Engineers Comments Regarding Surface Water Drainage

Application Reference:	A/184/25/DOC	Reviewer Reference:	ADC/EXT5/AF
Planning Officer:	Harry Chalk	Date of Review:	28/01/2026
Site Name:	Land East of 22 Speedwell Chase Speedwell Chase Angmering		
Application Description:	Approval of details reserved by condition imposed under A/121/23/PL relating to condition 11-surface water drainage.		
Assessment Number:	2

Appendix 5

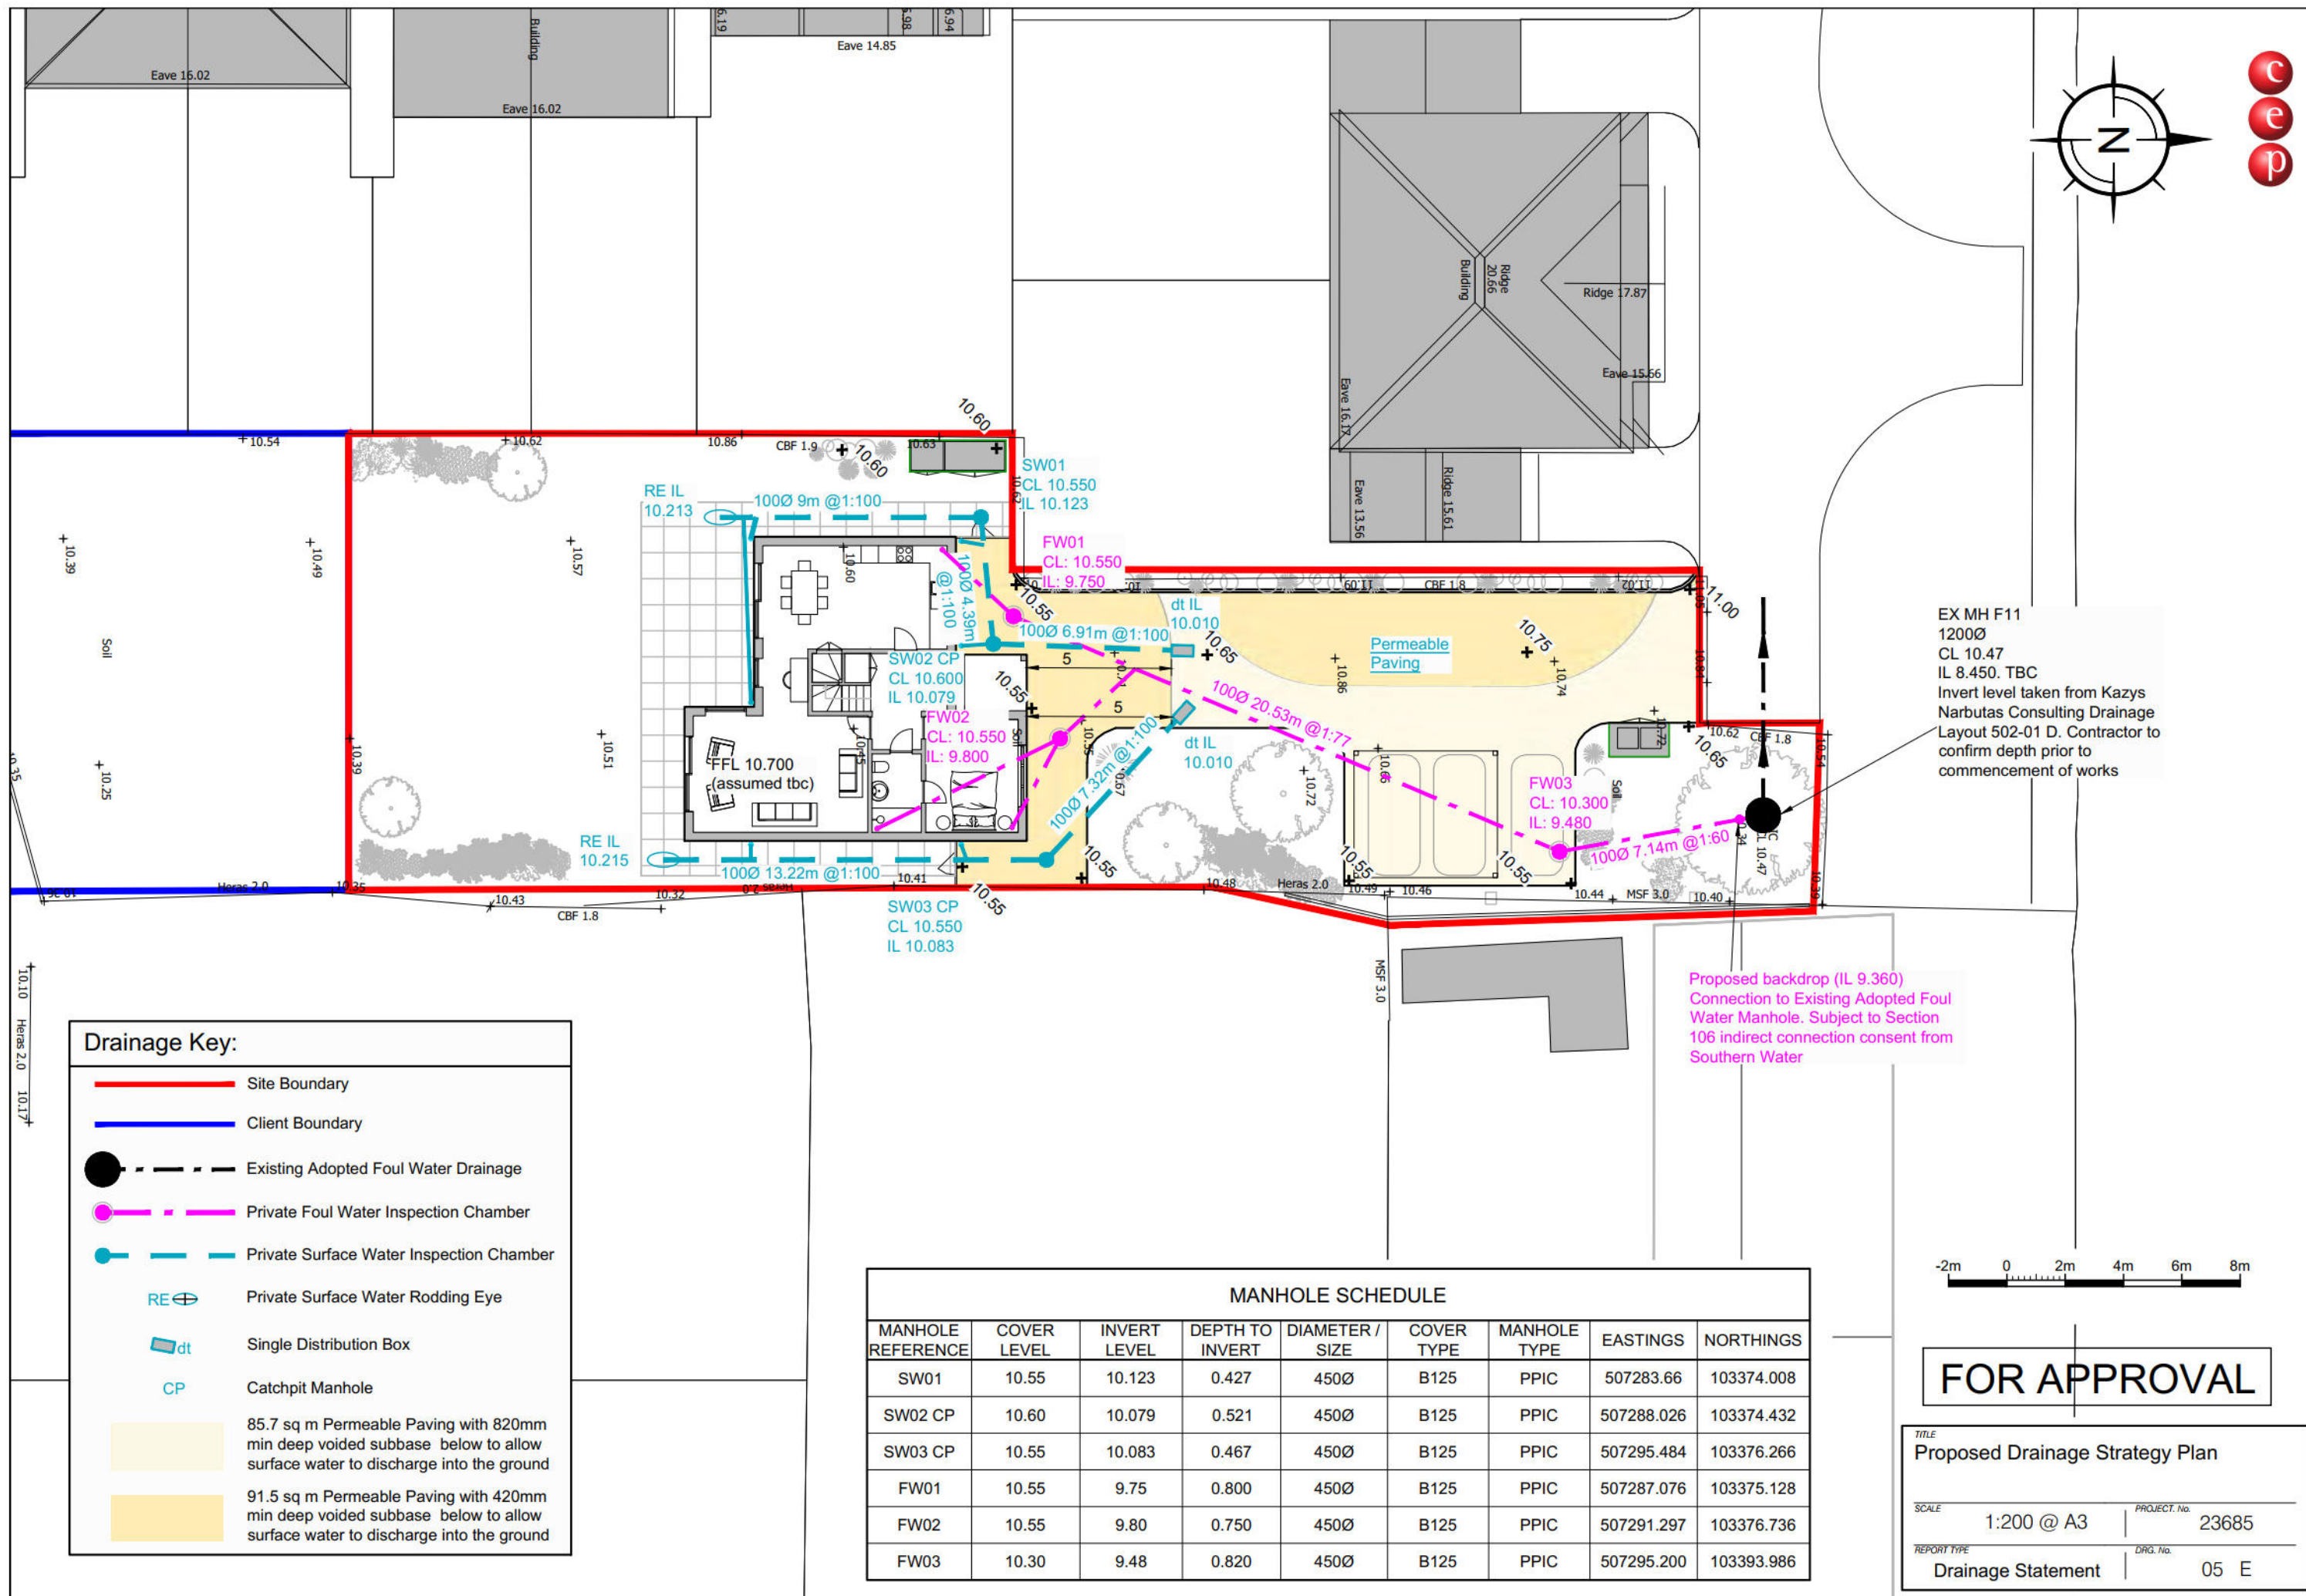
3	The drainage layout should show a Stage 4 Technical Design rather than Planning Strategy Plan and include full levels design. The layout should show the permeable pavement base levels rather than depths.	Appendix 5 of the Discharge of Drainage Condition 11 technical note provides the technical detail required for construction, including the proposed FFL, a manhole schedule with cover and invert levels, chamber type, and spot levels on the 'For Approval' Proposed Drainage Strategy Plan and the base levels of the permeable pavement on the Construction Details drawing. The drawings are attached at the rear of this response.	Response accepted. No further comment.		
4	There is foul drainage shown conflicting with a proposed tree position, this should be checked for viability of the proposed landscaping.	This refers to the tree shown clashing with the existing foul drain at the far northeast of the site that it is proposed the foul water from the development connects to. This is not an existing tree and is shown indicatively on the architects drawing for aesthetic purposes only. It has been removed from the drawing and the updated drawing 05 Proposed Drainage Strategy Plan Rev F drawings is	Noted. Case Officer to check whether proposed tree is required to be relocated or can be removed due to clash with existing infrastructure.

Appendix 7
Exceedance Flow Route Plan

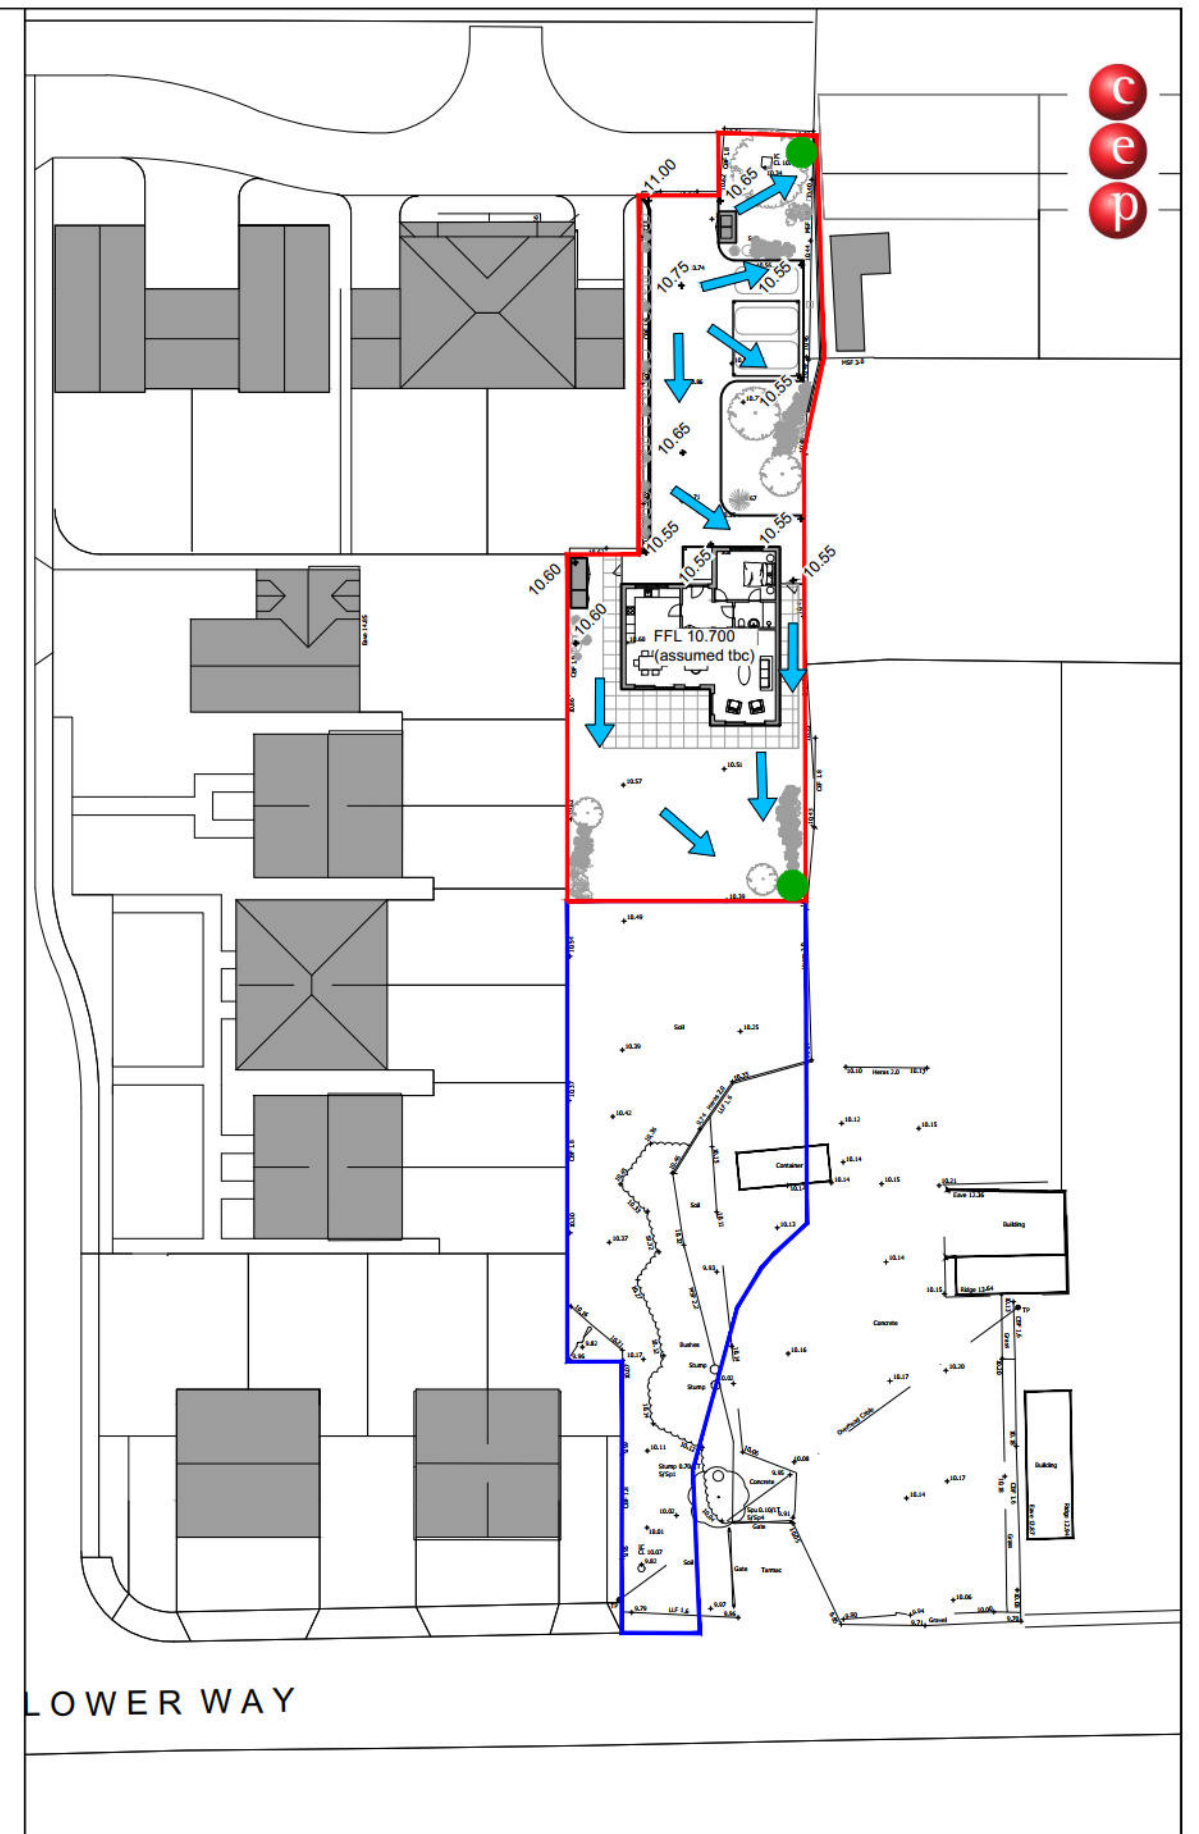
reduce the large volume of storage available. The post development exceedance route is across the permeable surface in the northern part of the site where water will drain through the surface even if partial blockage occurs. On the southern part of the site the exceedance route is around the dwelling across the garden where partial infiltration will occur. In the unlikely event of any water leaving the site, it will flow across gardens, parking areas and roads and no damage or inconvenience would result. Drawing 06 Exceedance Flow Route Plan is attached. A Factor of Safety of 1.5 is appropriate in this case.			
2	The half drain time for the 3/3AEP+CCA storm should be demonstrated to be less than 24 hours based upon the entire drained area.	The modelling software (Causeway Flow v16.0) confirms the half empty time for the 1:100 year plus climate change event as 1064 minutes, approximately 17.7 hours. The 1:30 year plus climate change half drain time is therefore also less than 24 hours.	Response accepted. No further comment.
